OFFICIAL NOTICE OF DECISION

CITY OF ALBUQUERQUE
PLANNING DEPARTMENT
DEVELOPMENT REVIEW BOARD

4. Project # 1002372

THOMPSON ENGINEERING agent(s) for DRAGONFLY DEVELOPMENT INC request(s) the above action(s) for all or a portion of Tract(s) 223 & 224, AIRPORT UNIT, TOWN OF ATRISCO GRANT (to be known as **LAS PLAYAS SUBDIVISION**) zoned R-2, located on GLEN RIO RD NW, between 68TH ST NW and 72ND ST NW containing approximately 9 acre(s).
[REF: 02DRB-01827] (J-10)

Preliminary Plat LAS PLAYAS

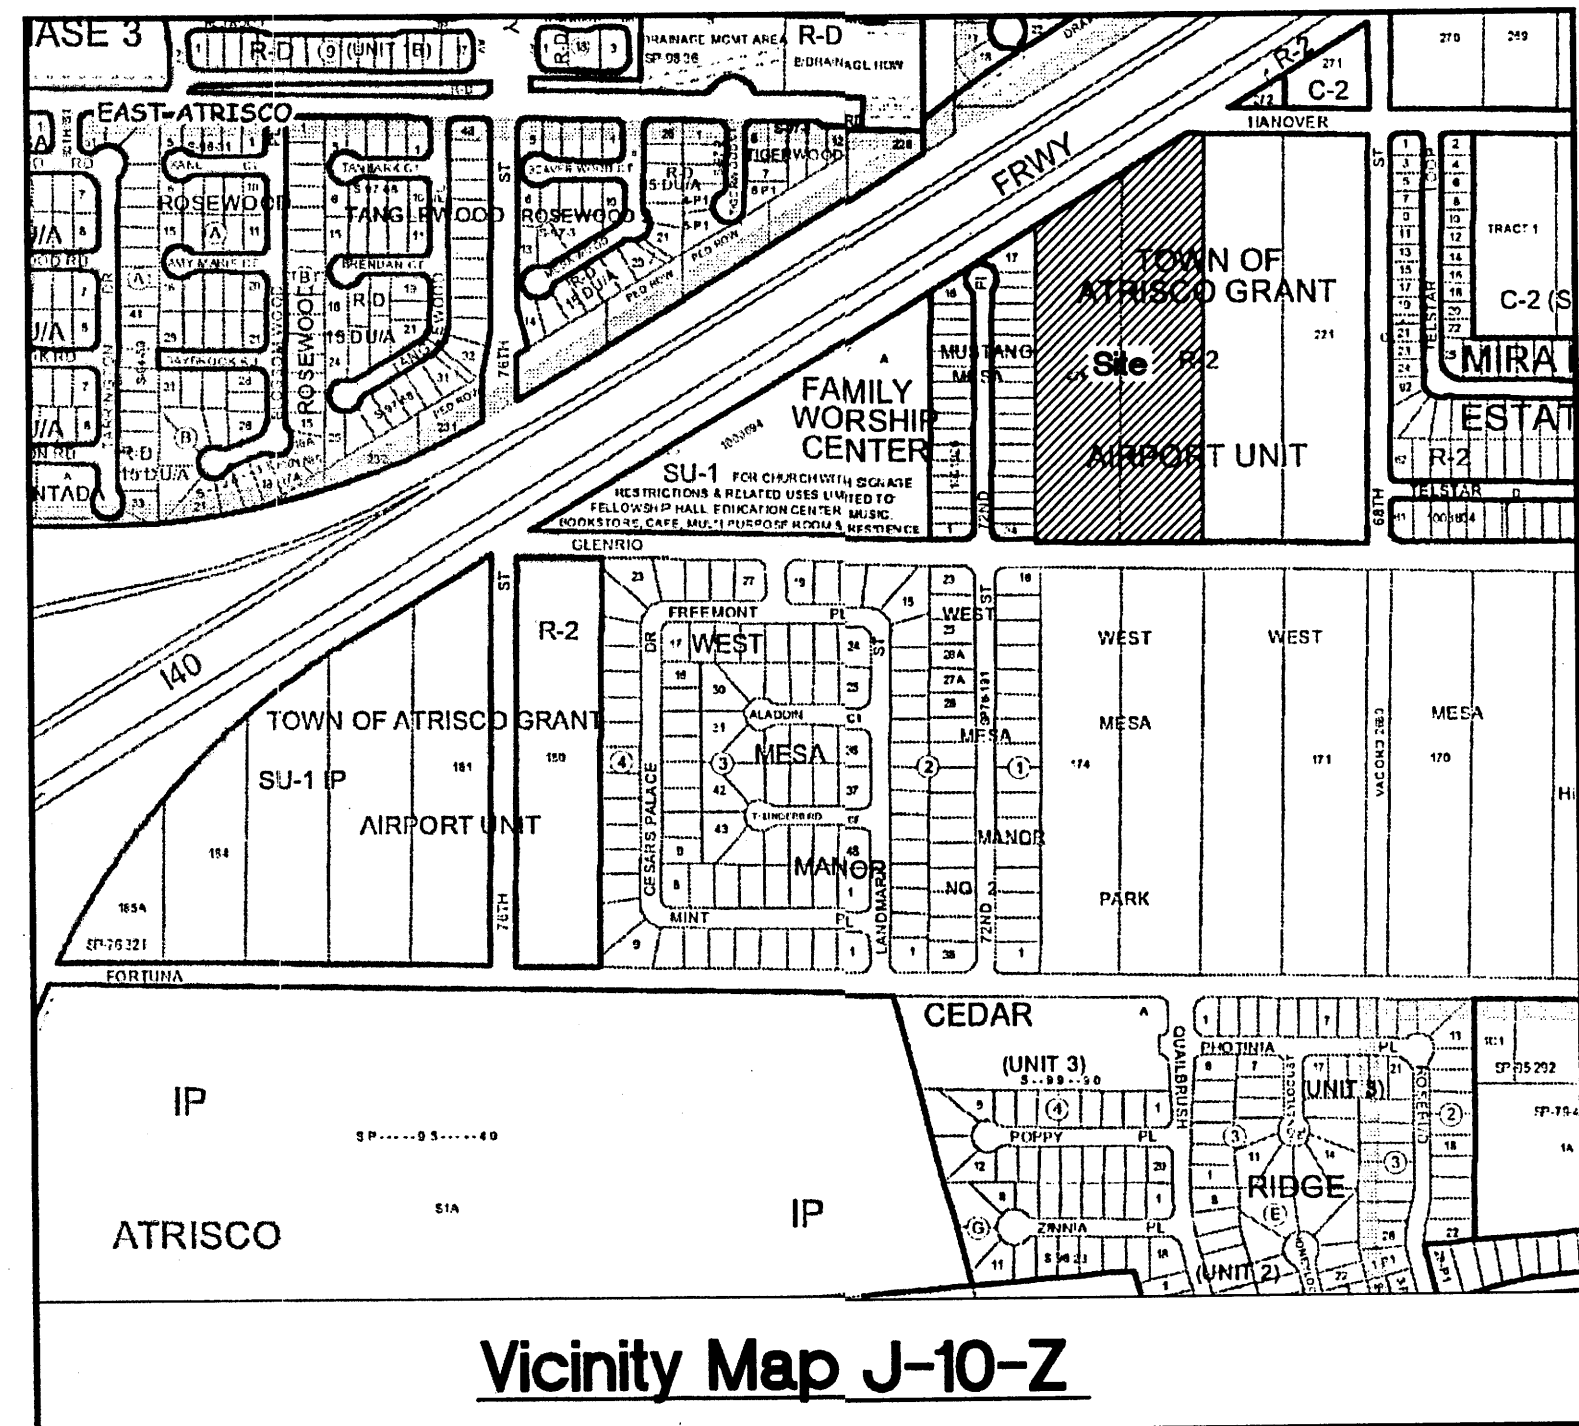
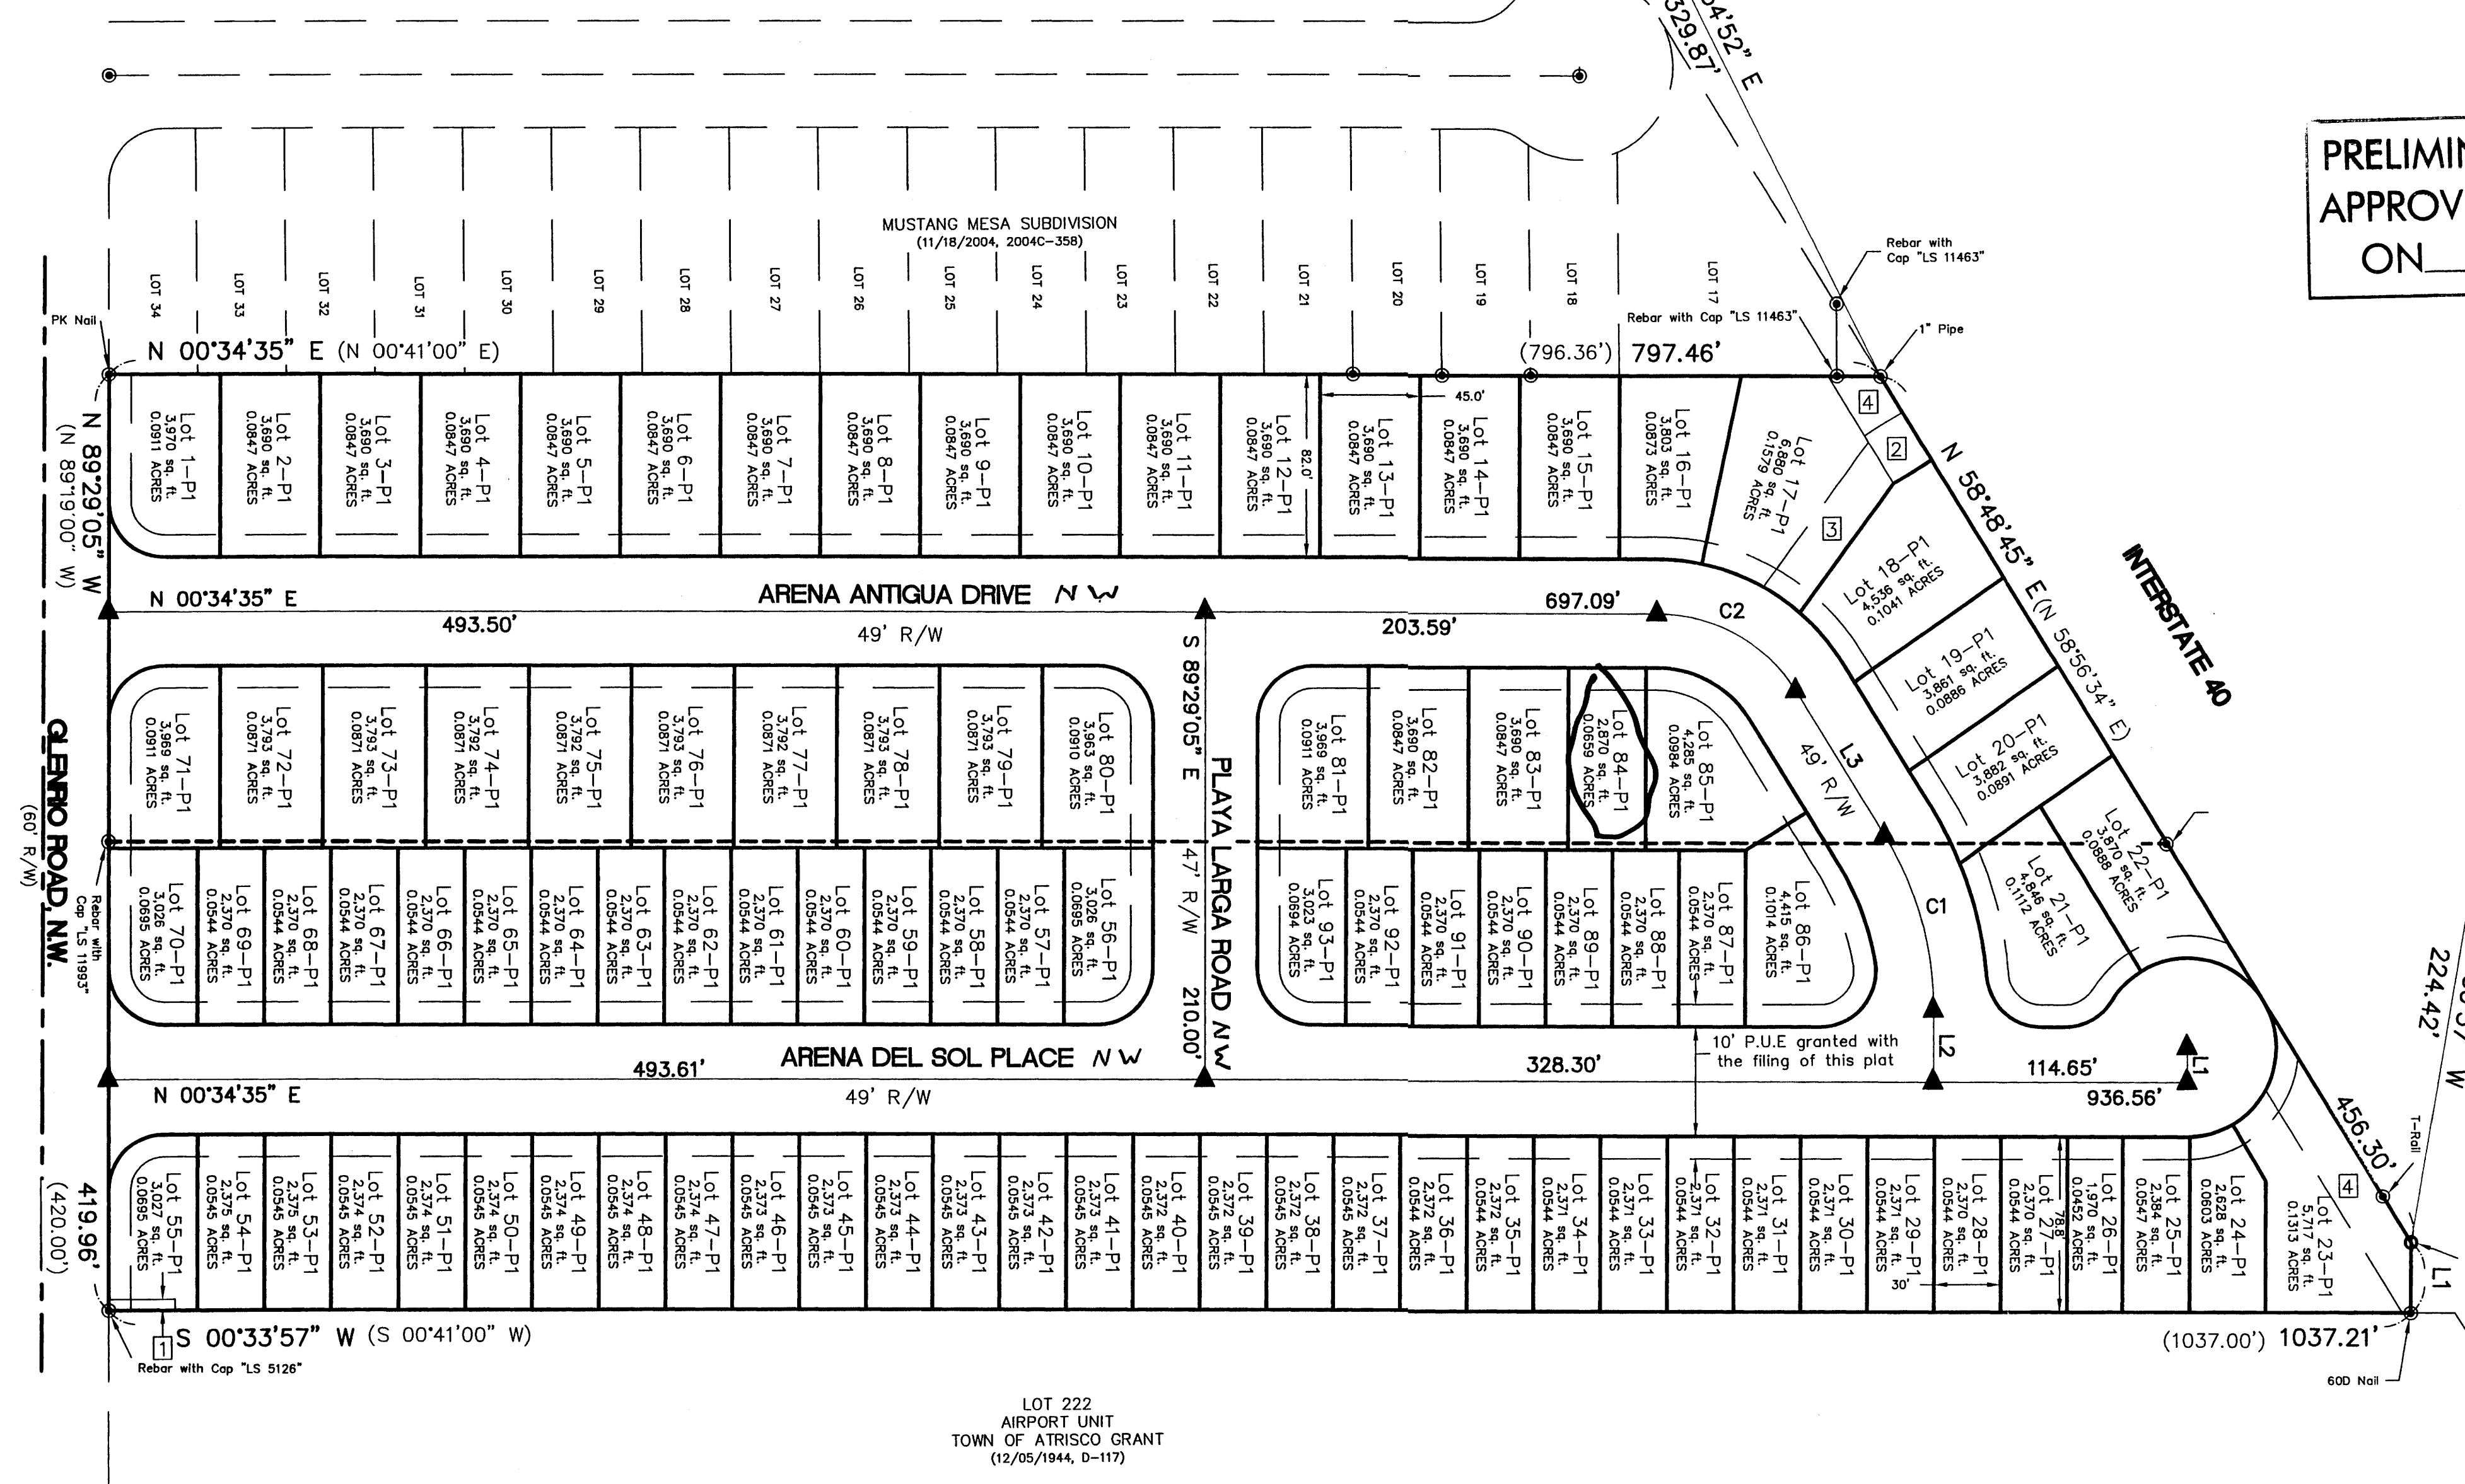
A note is required on the plat stating which lots are townhomes and which are single family homes.
